Our Ref: F2025/00890
(Contact Officer: Joseph Edmonds, ph: 9093 6955)

Reference number	SSD-81426710
Subject Land	138 Maroubra Road, Maroubra
Proposal:	Construction of a nine-storey mixed-use development comprising a residential flat building and ground floor retail premise, including: - 27 x 1-bed apartments, including 7 affordable dwellings - 14 x 2-bed apartments, including 6 affordable dwellings - 23 x 3-bed apartments - Communal open space at rooftop level and on level two Replacement of an existing single level of basement to provide basement car parking, plus additional parking provided above ground on the first storey. The application is seeking an infill affordable housing bonus under the SEPP Housing 2021, noting that 13 affordable housing units are proposed within the scheme.

I refer to your request for Council's review of the Mixed-use development with in-fill affordable housing at 138 Maroubra Road, Maroubra. The following comments are provided for your consideration.

DRAWN BY	SCALE	SHEET SIZE	PRINT DATE
Author	A1	A1	18/09/2025
DESCRIPTION	SUN EYE VIEWS SHEET 3		
PROJECT No	DRAWING No	REVISION	
21_435	DA8.311	B

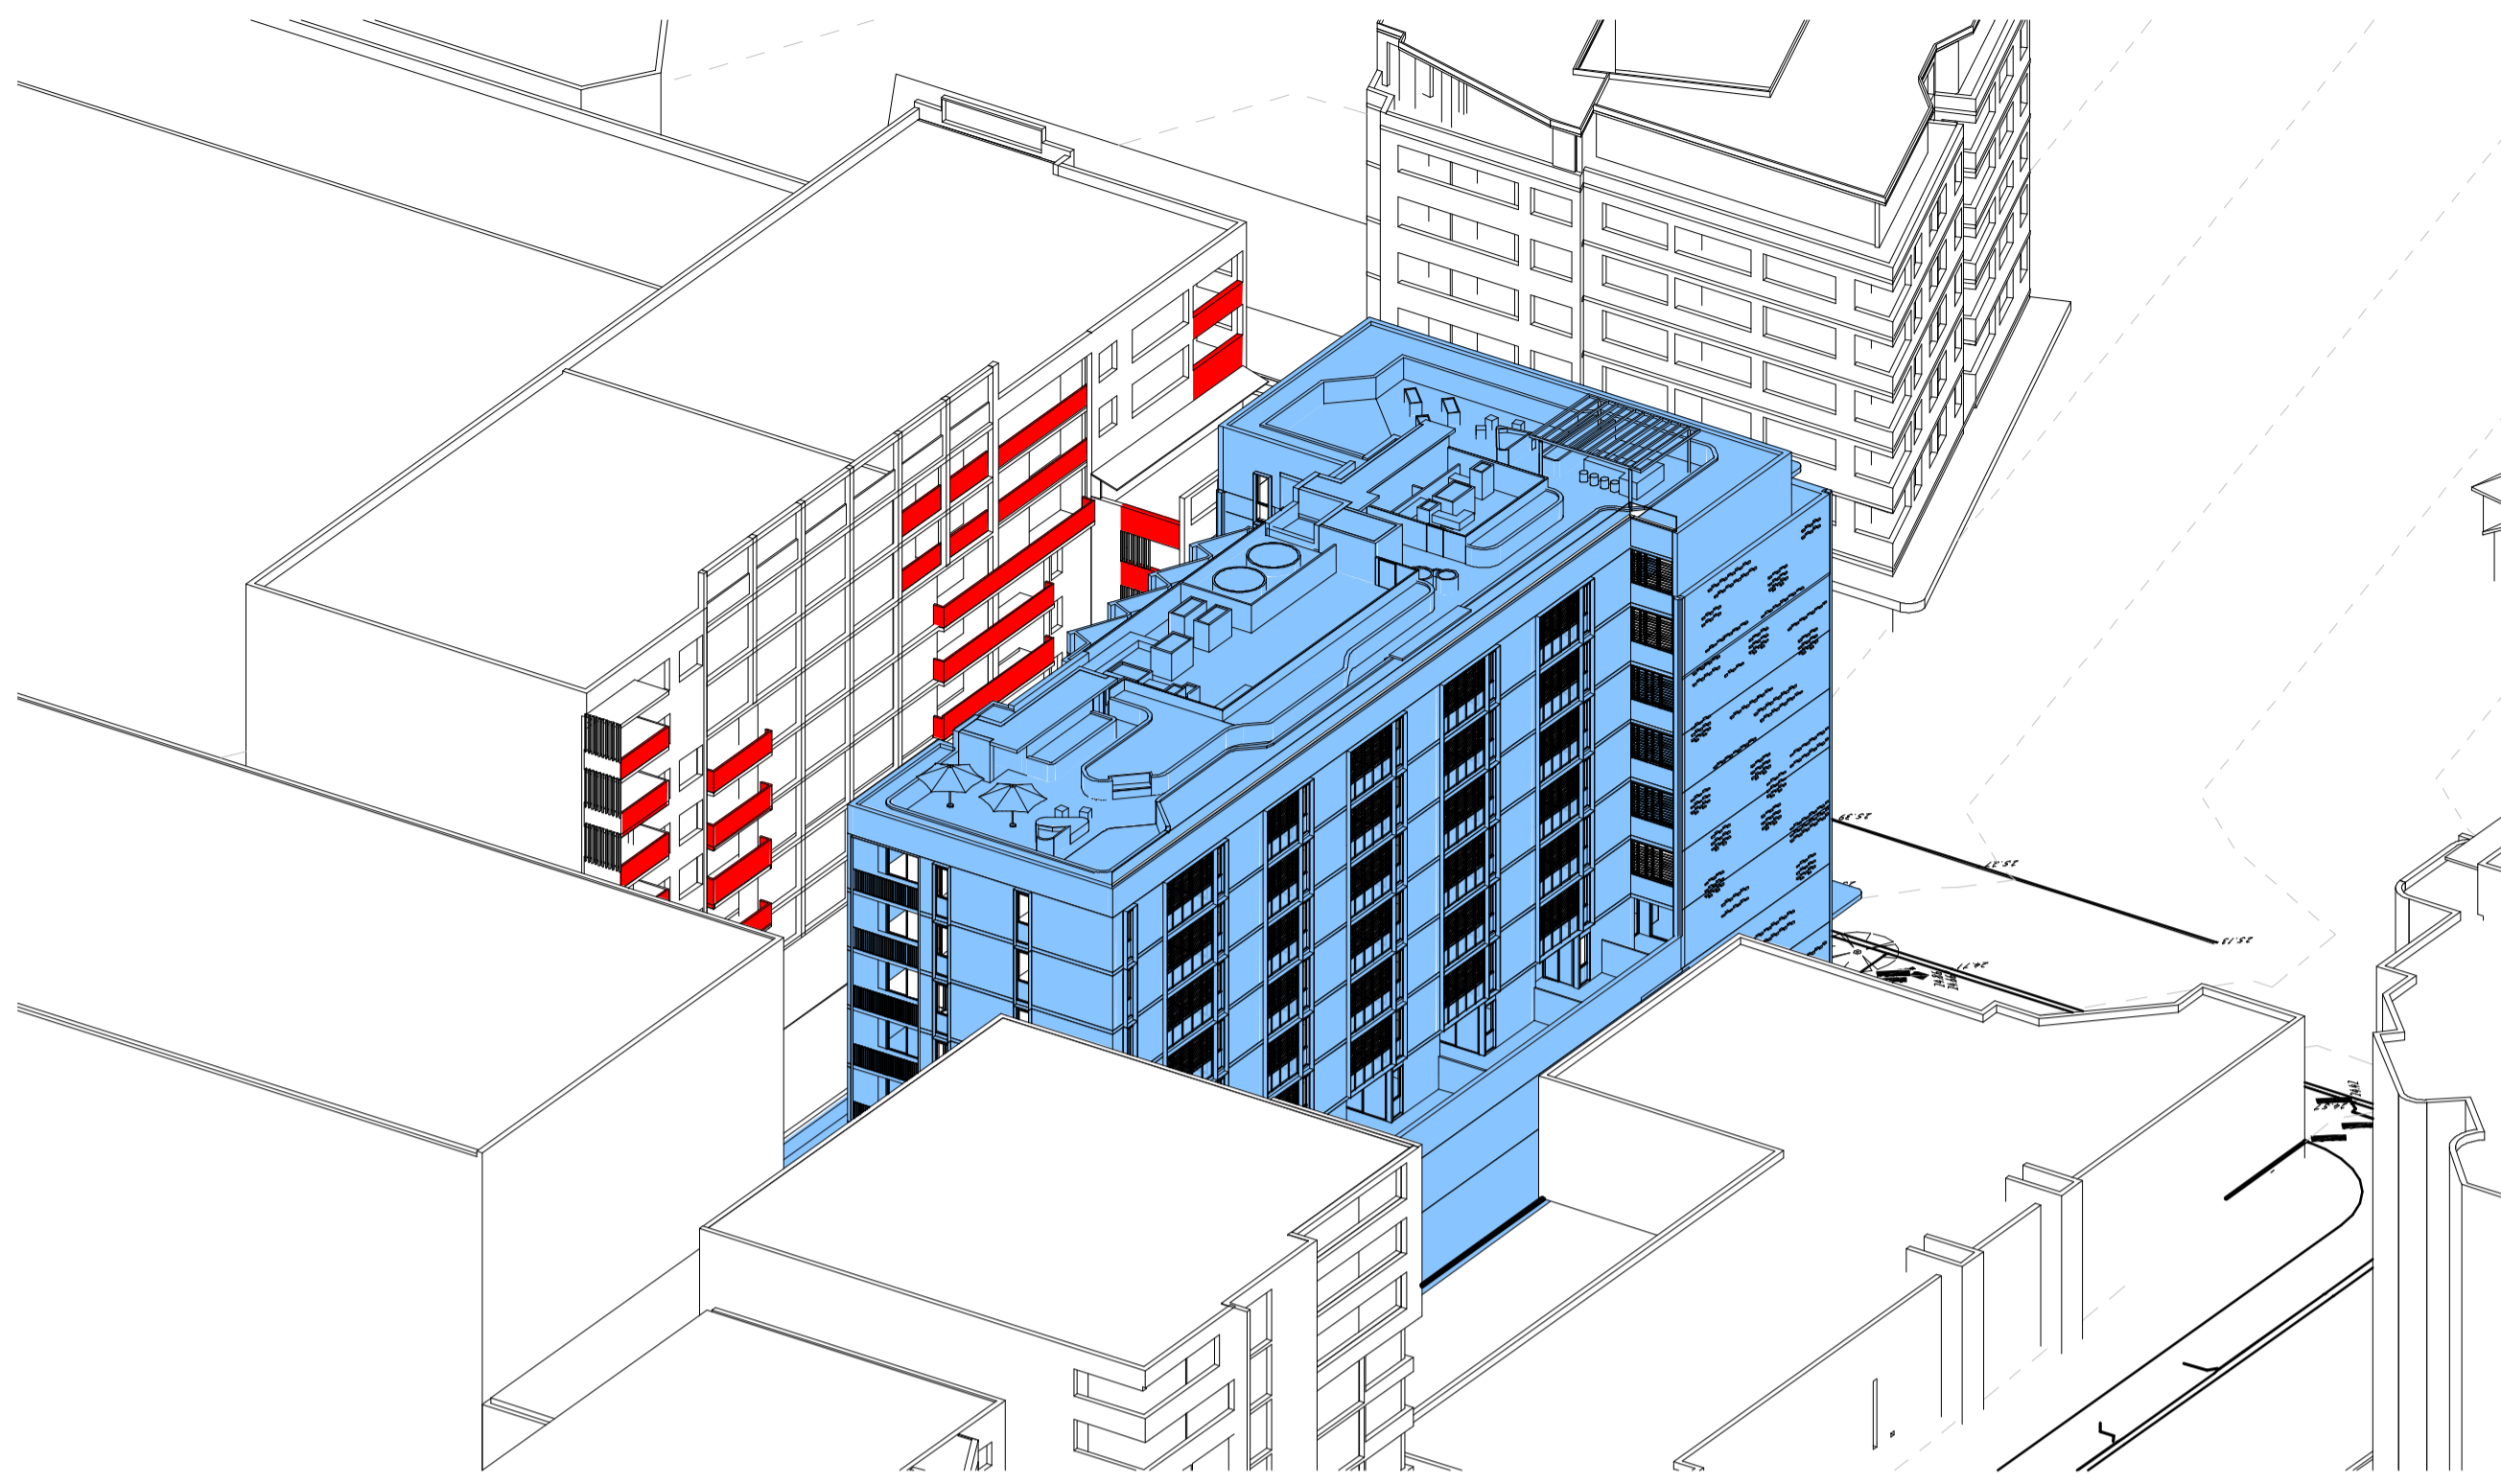
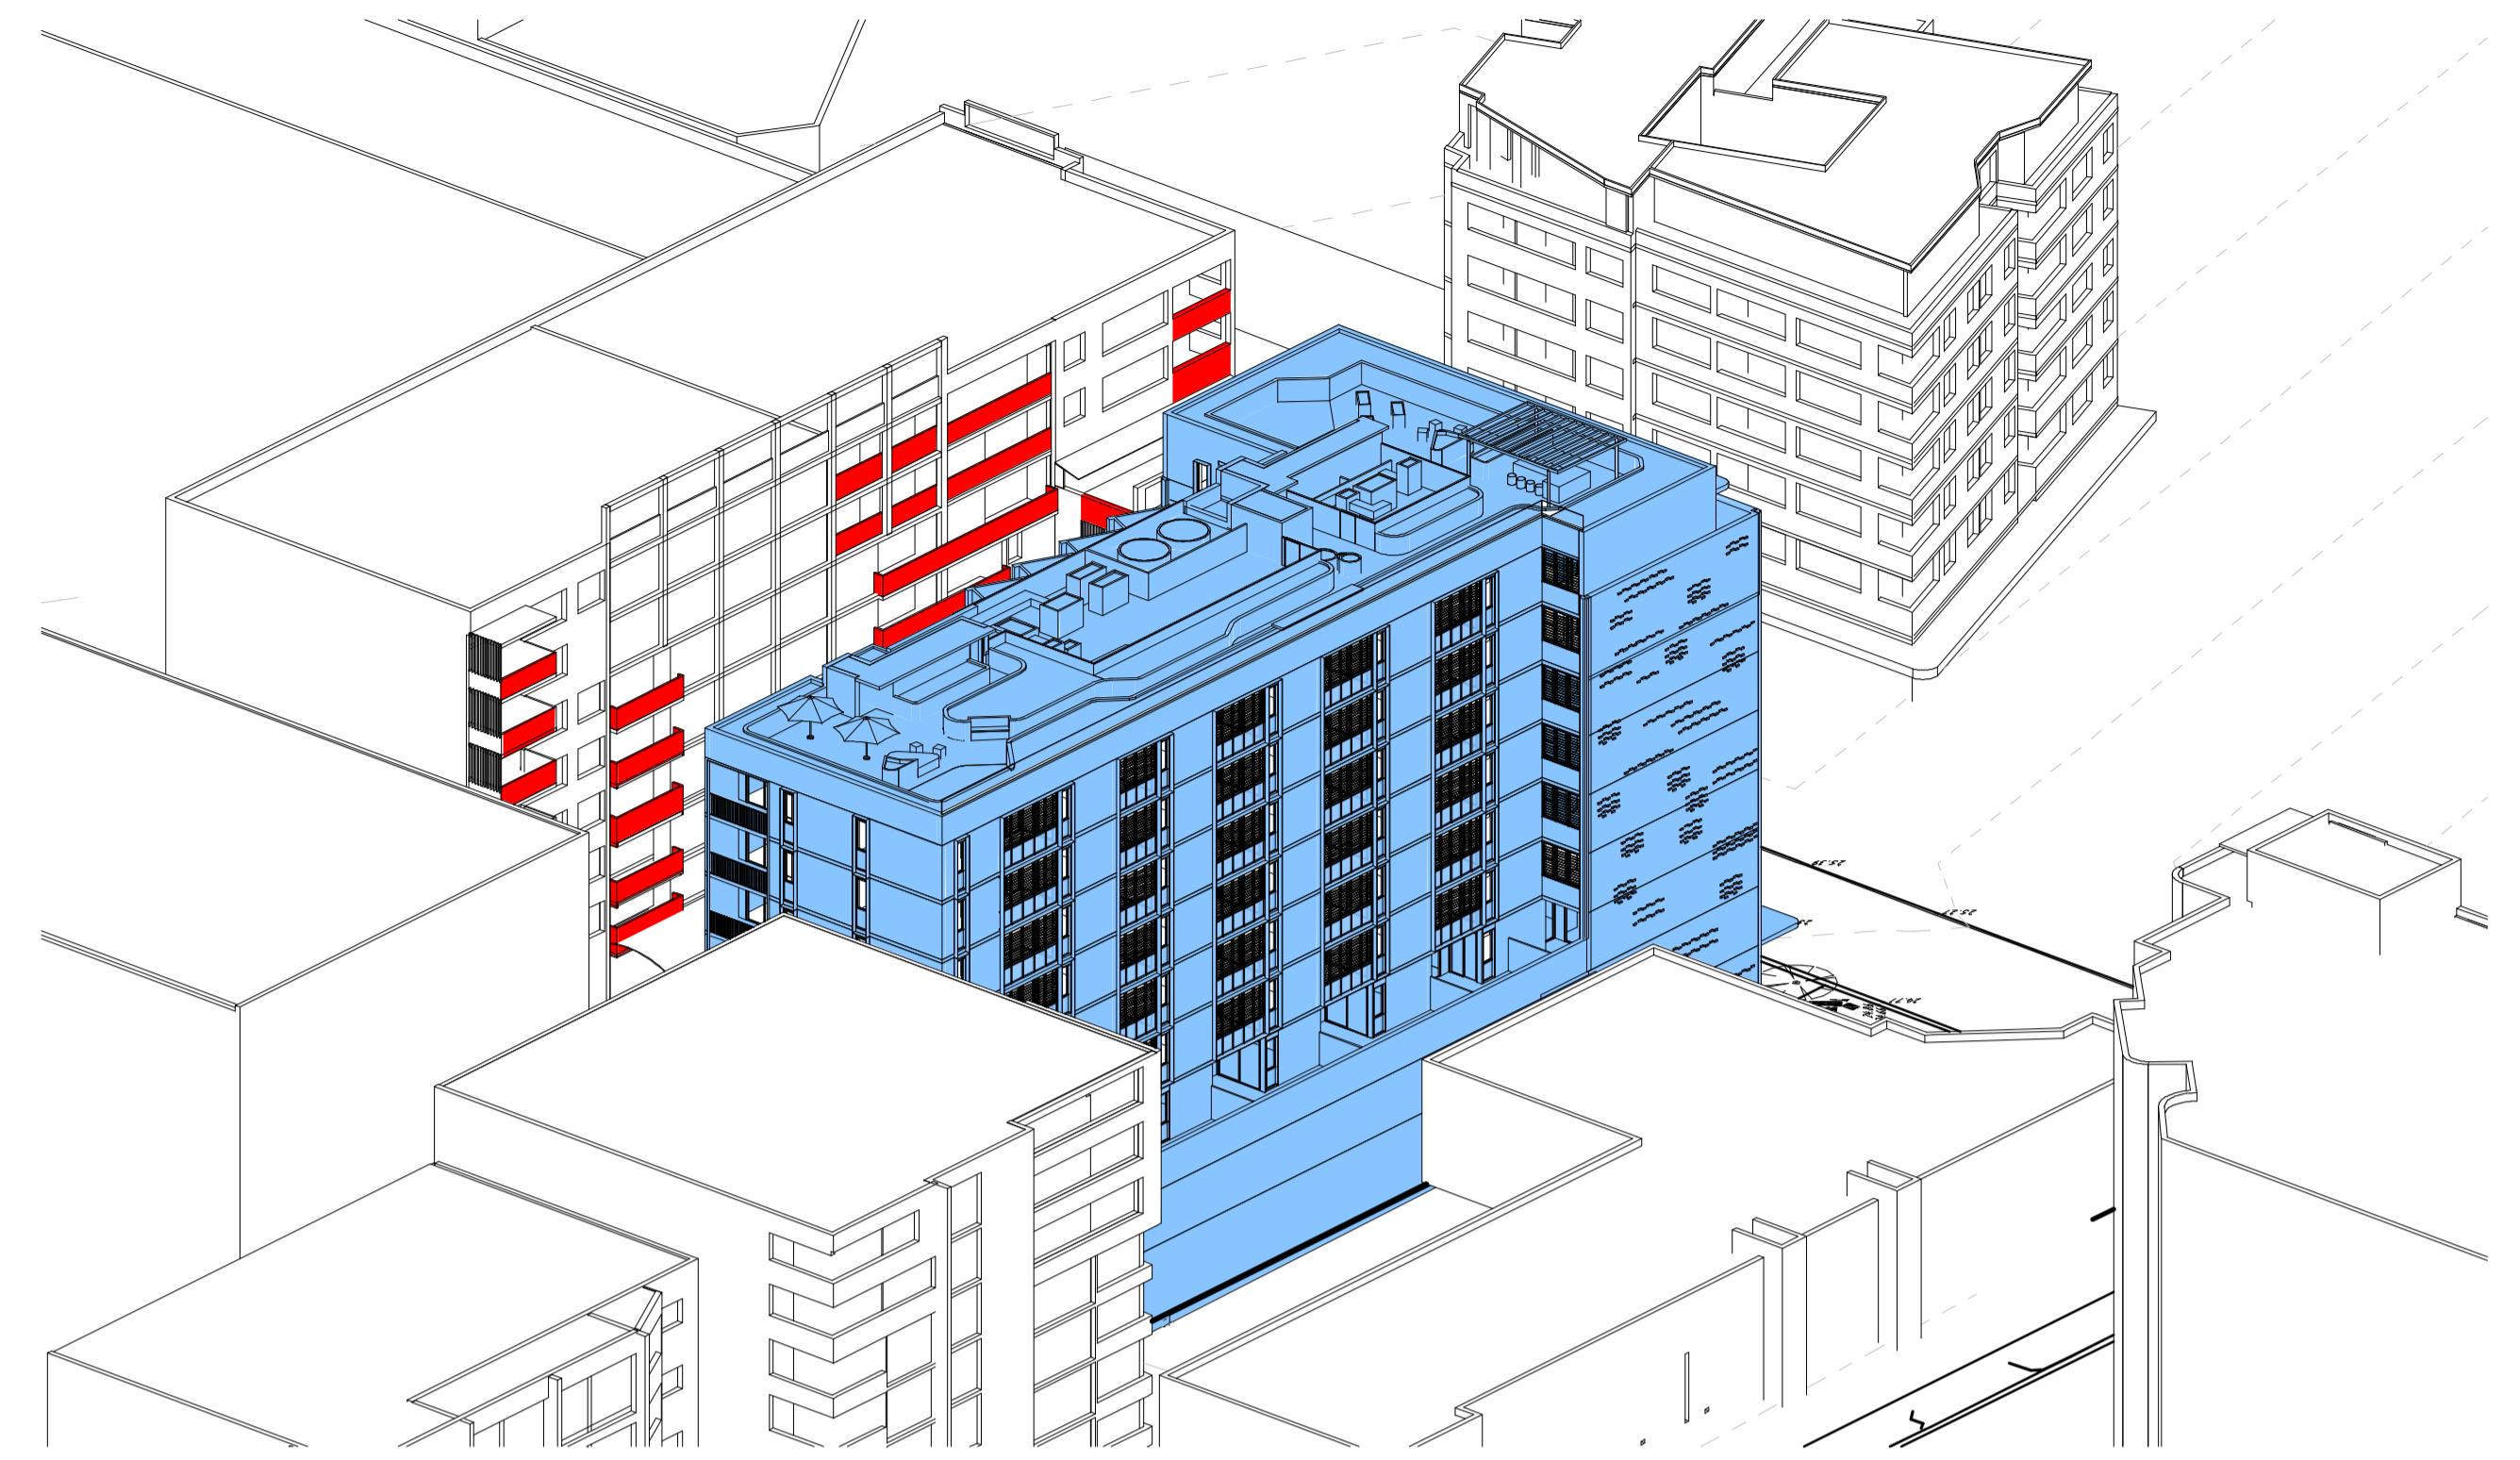
As shown in the Eye of the Sun Diagrams much of the development will not receive sunlight in the case of a similar scale redevelopment of the Police Station to the west and that sunlight access would be predominantly lost from 1:30pm to 3pm.
